Application by Tritax Symmetry (Hinckley) Limited for an Order Granting Development Consent for the Hinckley National Rail Freight Interchange – Deadline 4 submission

Deadline 4 response

Response to questions posed by the Examining Authority

Written Statement of Oral Case ISH6 [Appendix C – Plan for A47 link road footway/cycleway design]

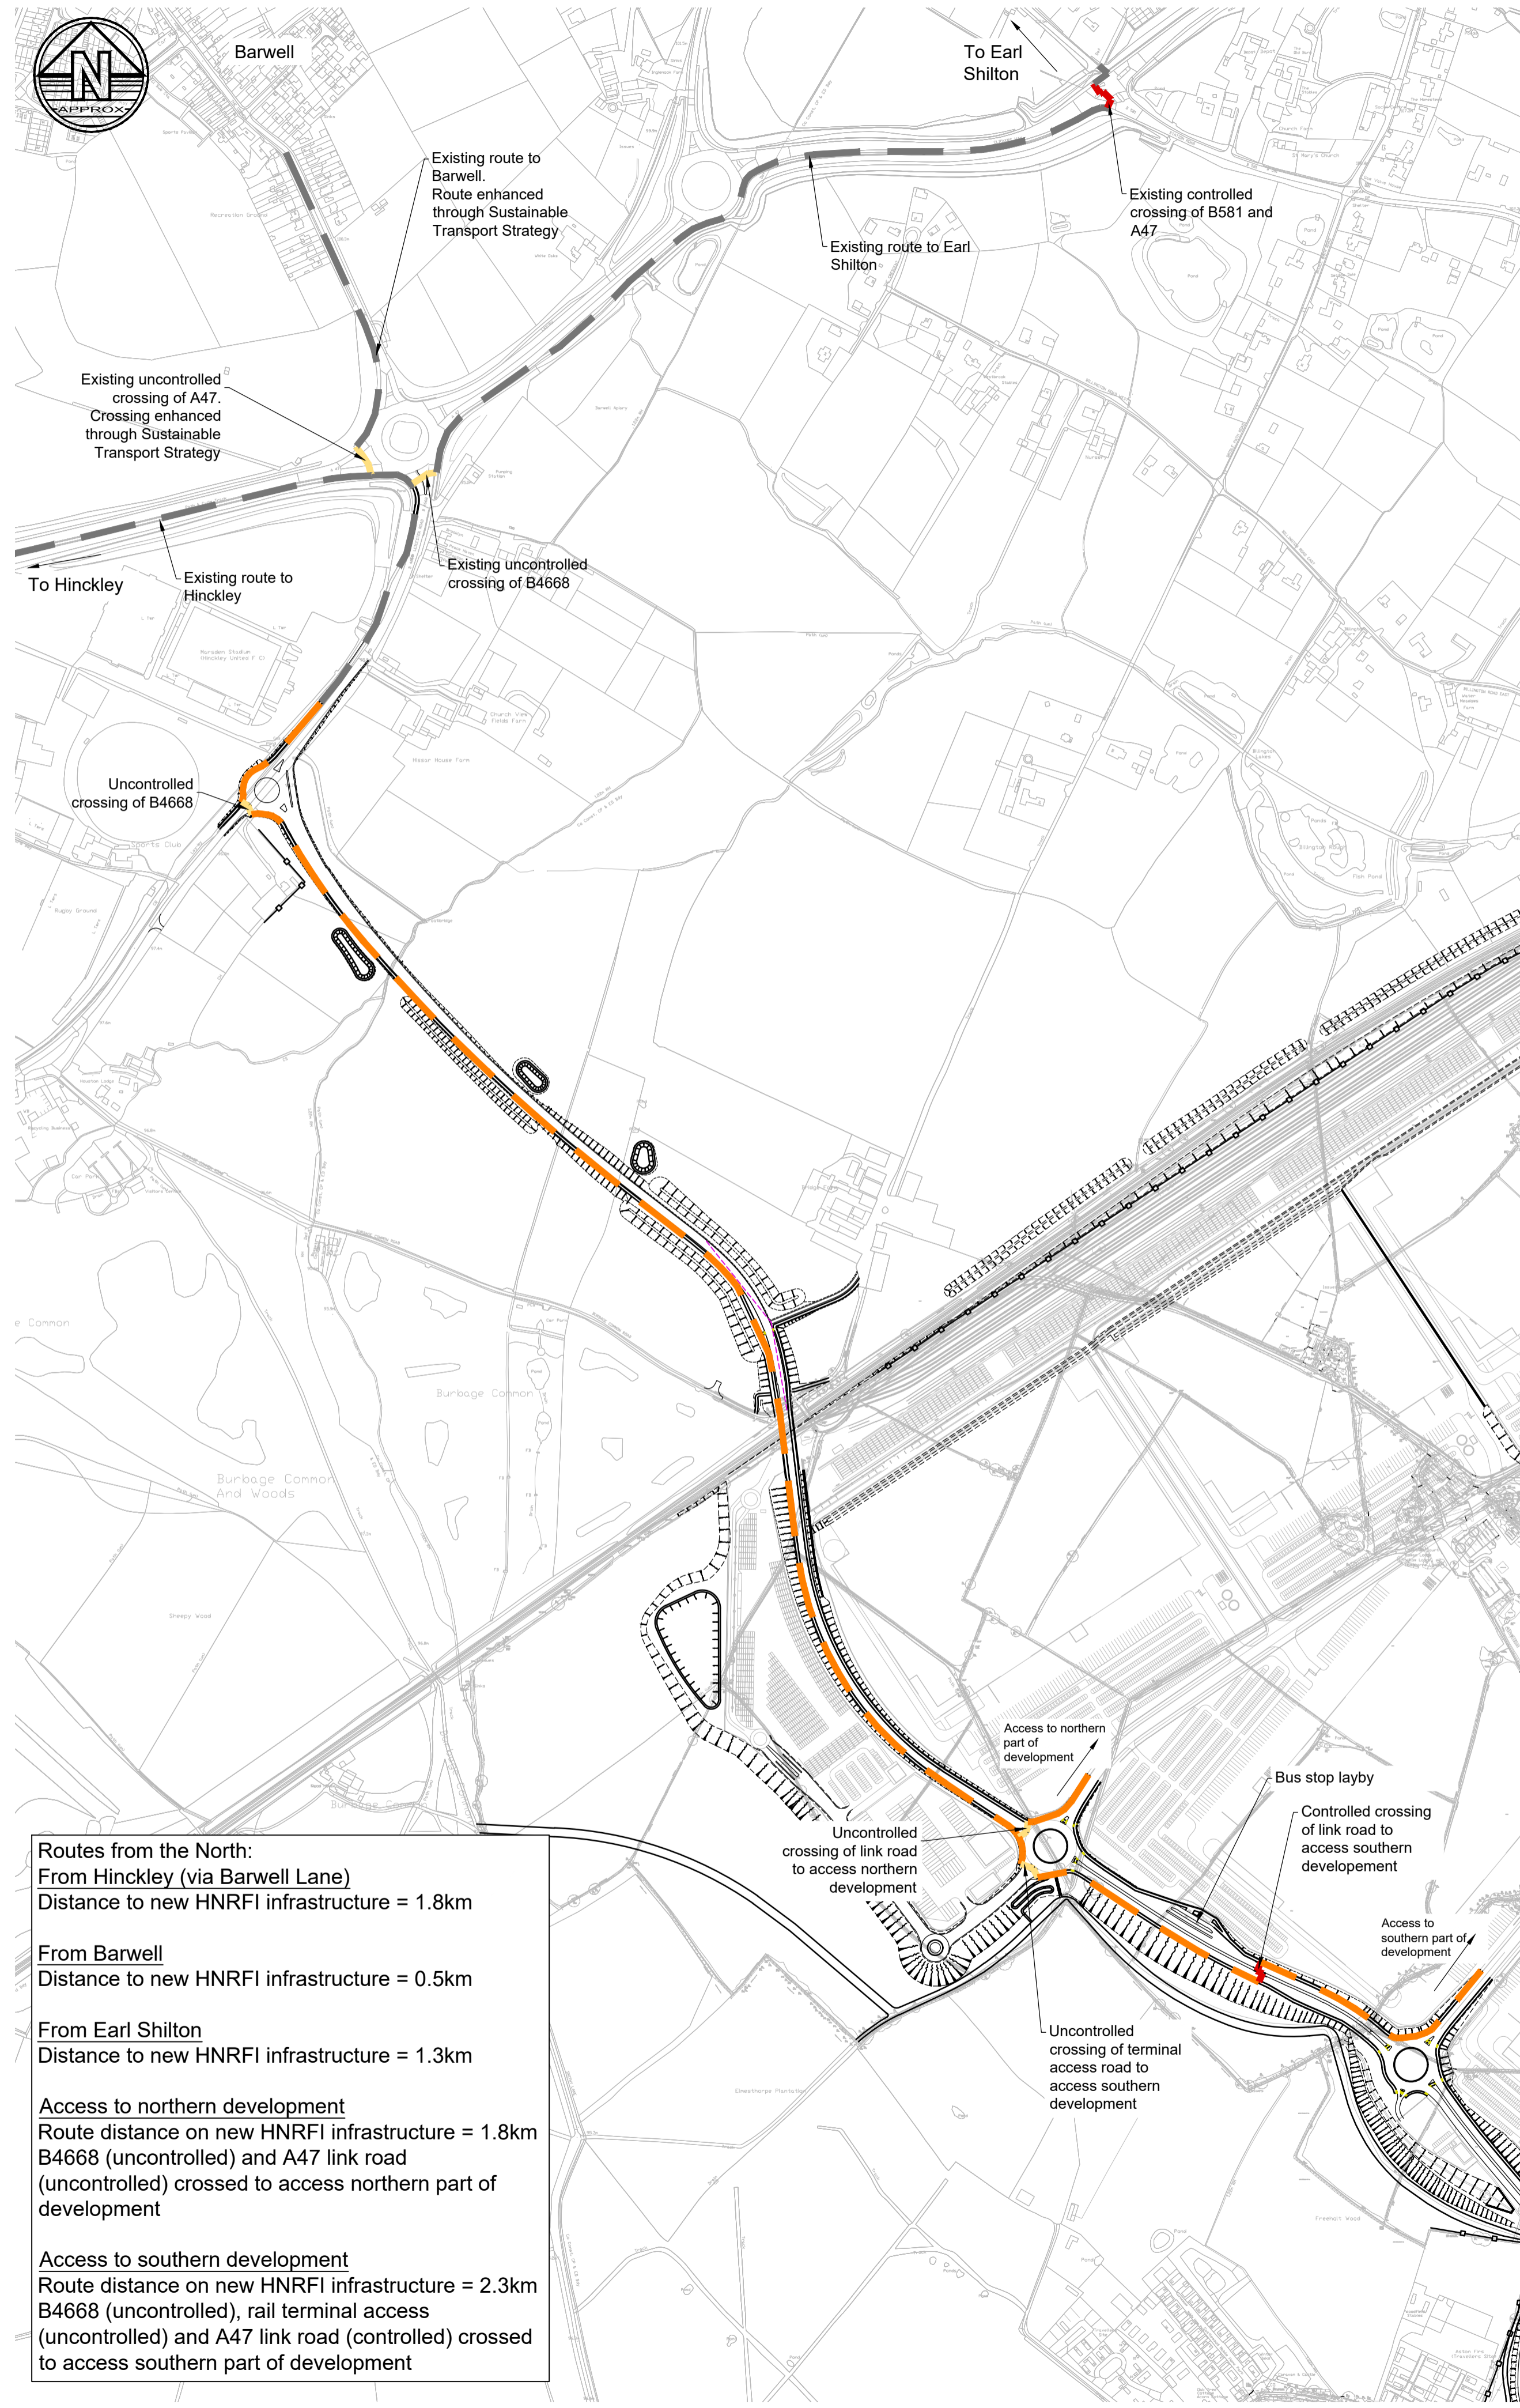
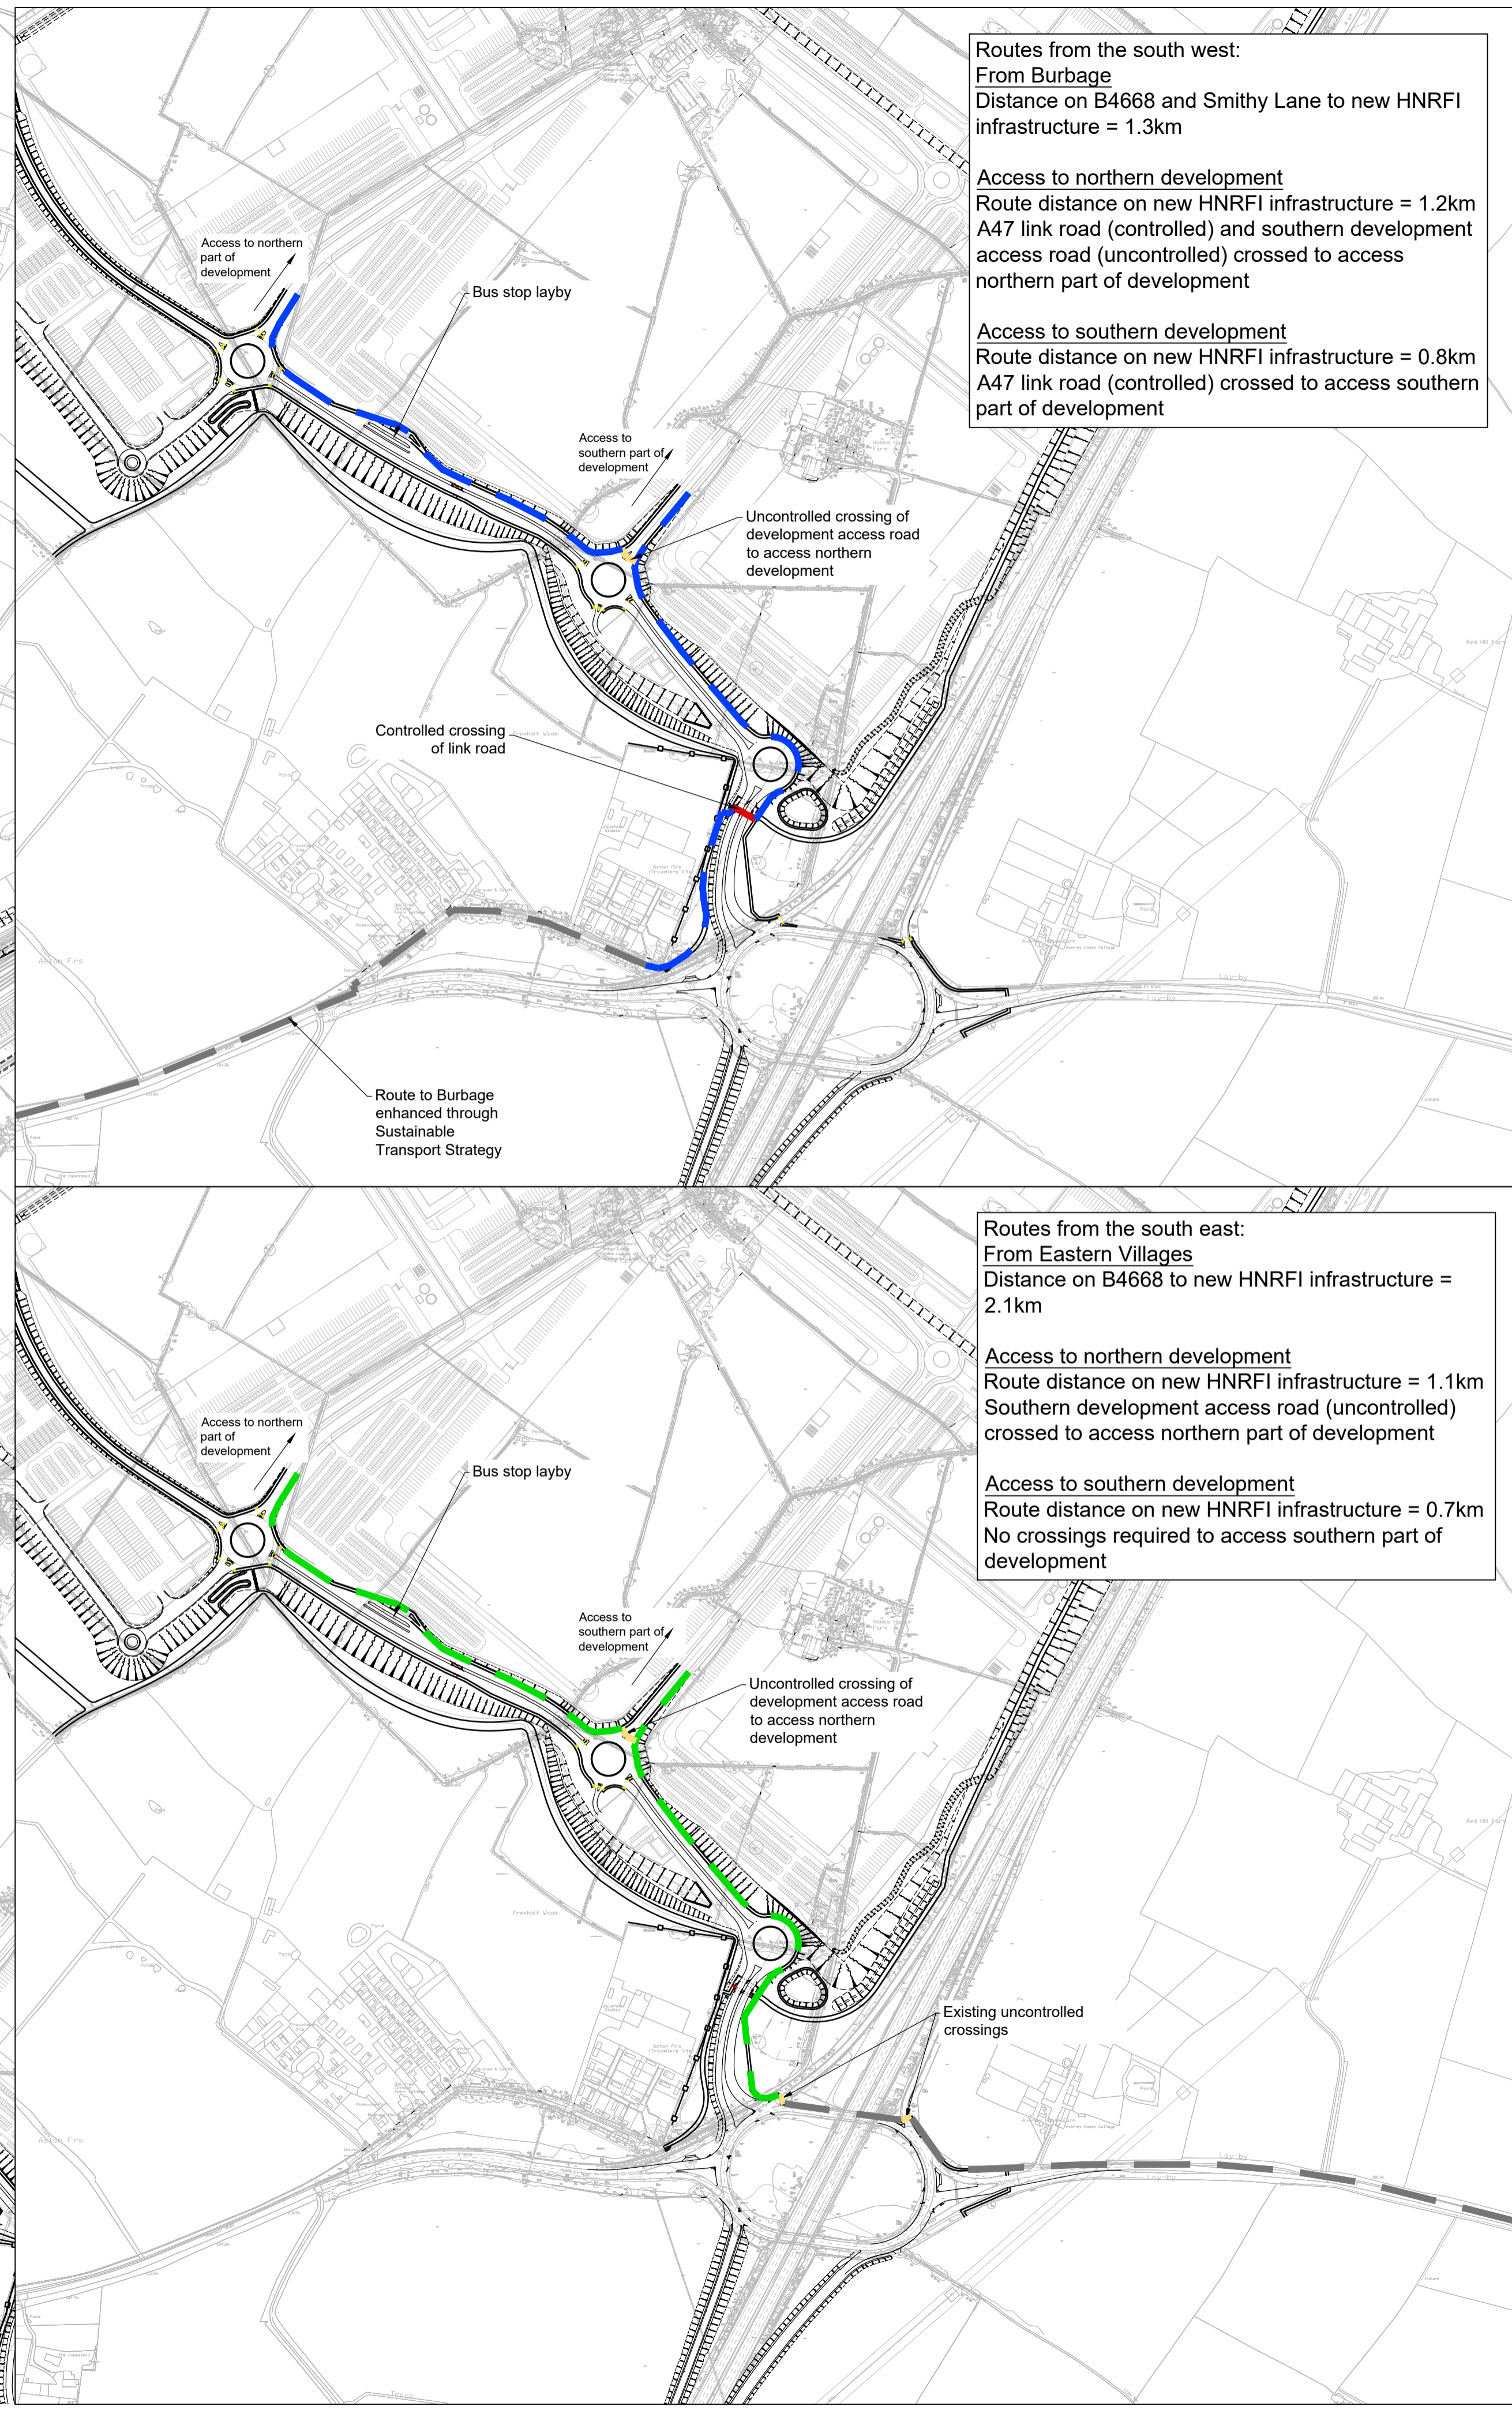
Examination library reference	Document name	Leicestershire County Council comments
REP3-003	2.4A Hinckley NRFI Highway Plan - sheet 1 of 8	This annotated drawing confirms that footway/cycleway provision is only made on one side of the A47 link road (albeit it crosses the link road in various locations). It is unclear why a consistent footway/cycleway is not provided along either both sides of the A47 link road, or indeed consistently on the development side of the road.
REP3-004	2.4D Hinckley NRFI Highway Plan - Sheet 4 of 8	This annotated drawing confirms that footway/cycleway provision is only made on one side of the A47 link road in some locations. It is unclear why a consistent footway/cycleway is not provided along both sides of the road.
REP3-005	2.29 Hinckley NRFI Geometric Design Strategy Record	LCC welcomes submission of this document. LCC will review the document in line with a detailed design review prior to ISH6. It was not possible for LCC to carry out any detailed design review prior to Deadline 3 submissions on the basis of the scale of drawings submitted. This was referenced throughout the LCC Written Representations (REP1-152).
